Response to Submissions (RtS) report on Dewatering Facility at 81 Gow Street, Padstow (SSD-10450)

Council has reviewed the Response to Submissions (RtS) documents prepared by the Applicant and exhibited by the Department of Planning and Environment (Department). Based on our review, Council requests that the following conditions of consent be added to the State Significant Infrastructure Application:

DRAWING TITLE
DRAINAGE LONGITUDINAL
SECTIONS
SHEET 1 OF 3

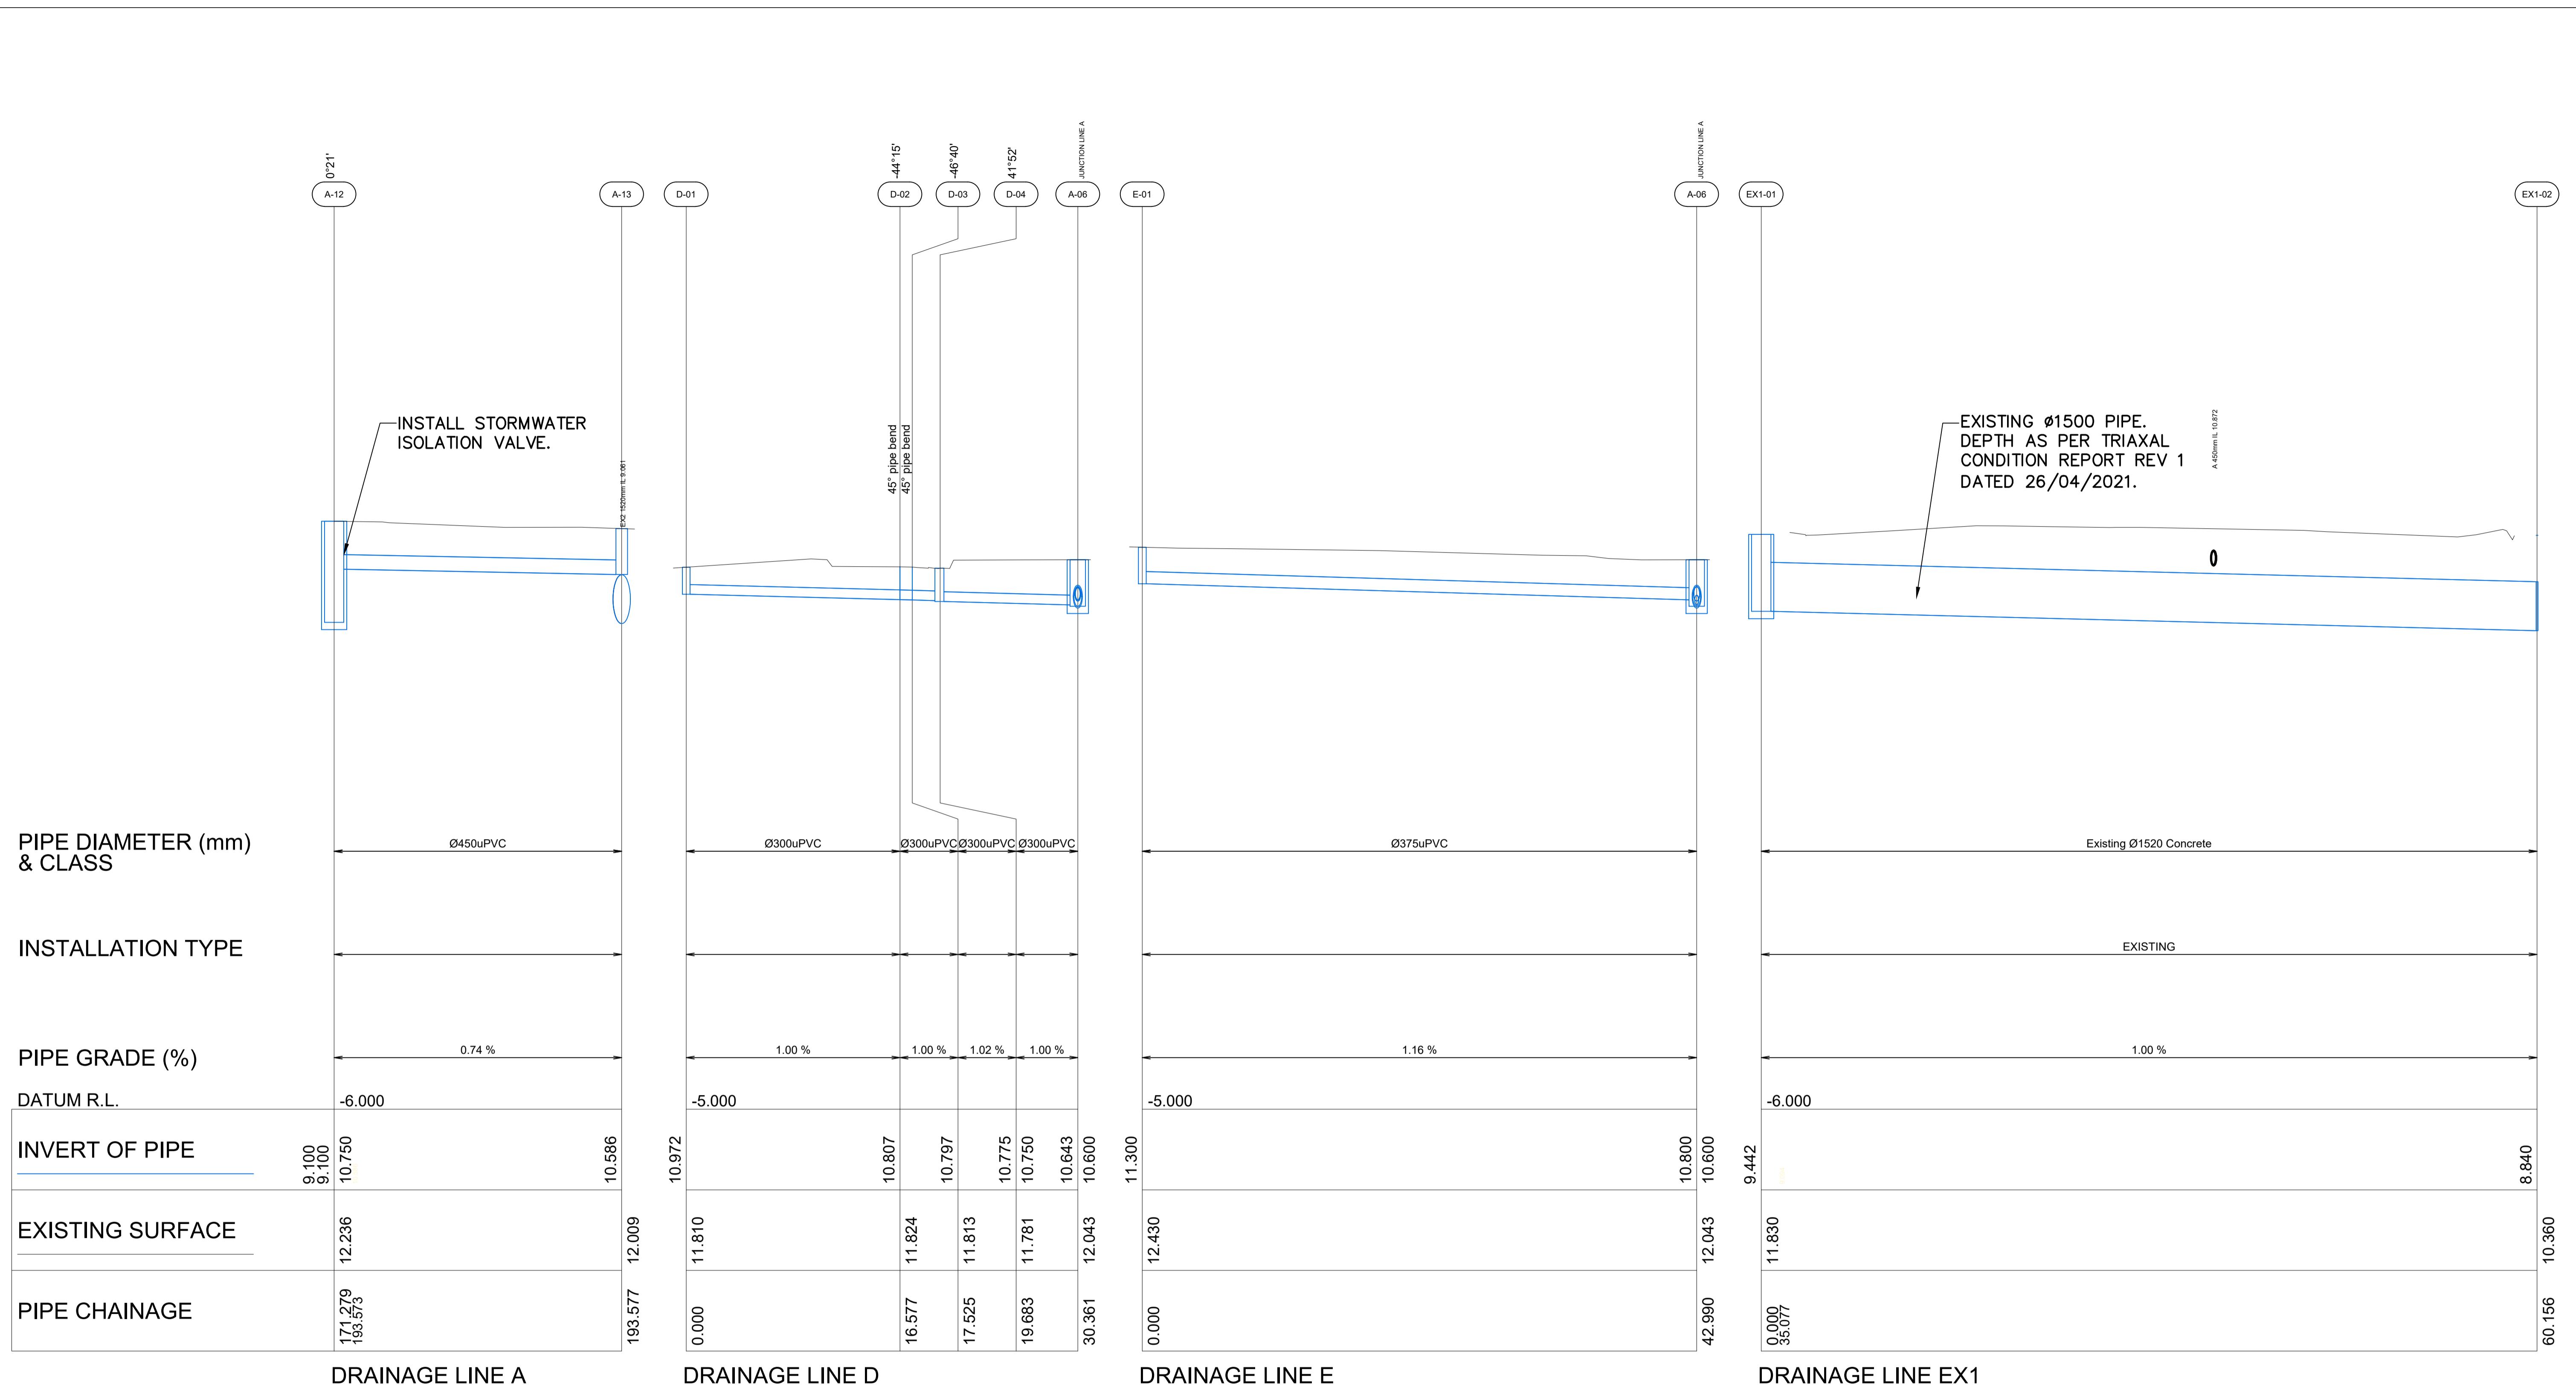
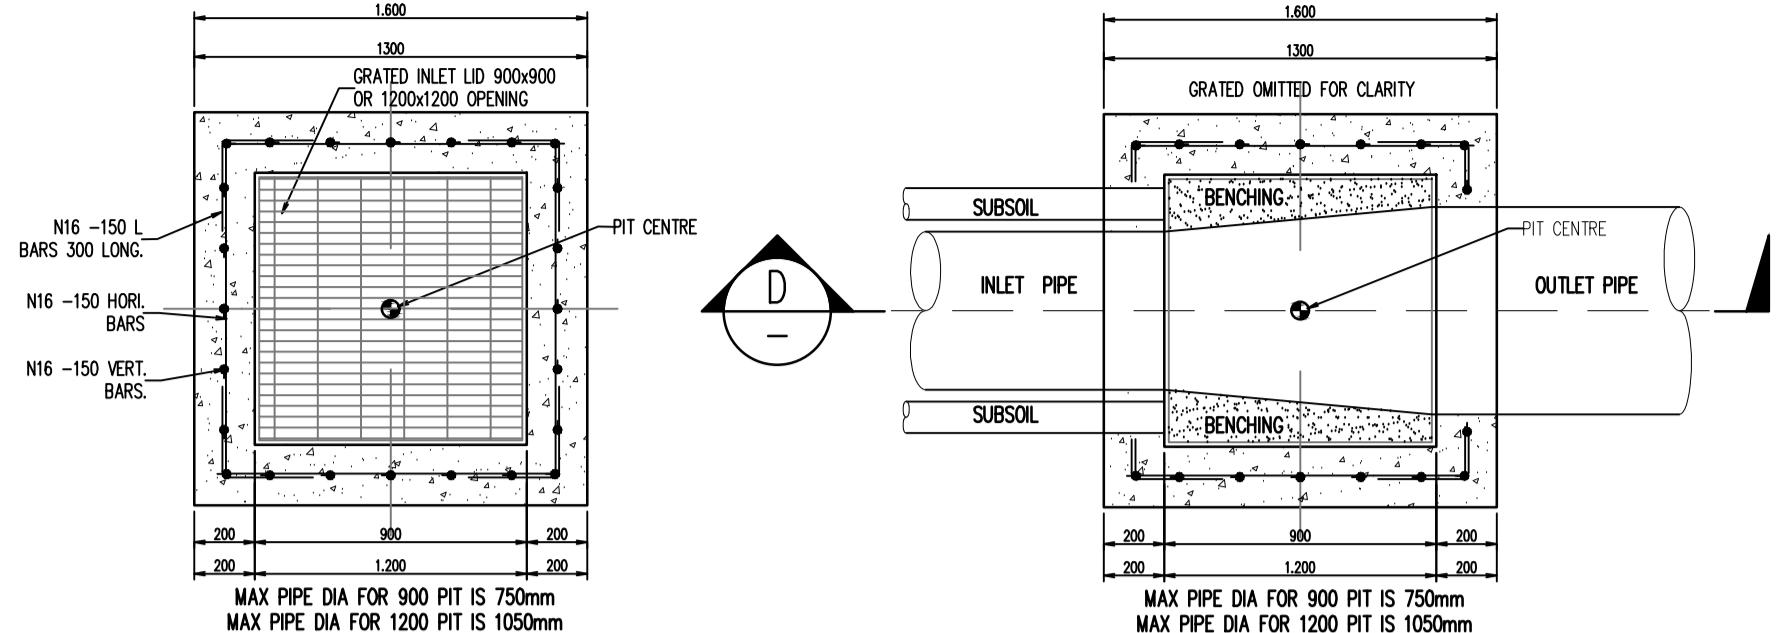
- After the connection, the pipe shall be flushed with a high-pressure water jet
 - After pipe being flushed, CCTV footage shall be provided to confirm the quality of the connection of the 375 mm stormwater pipe to the Council 1500mm pipe
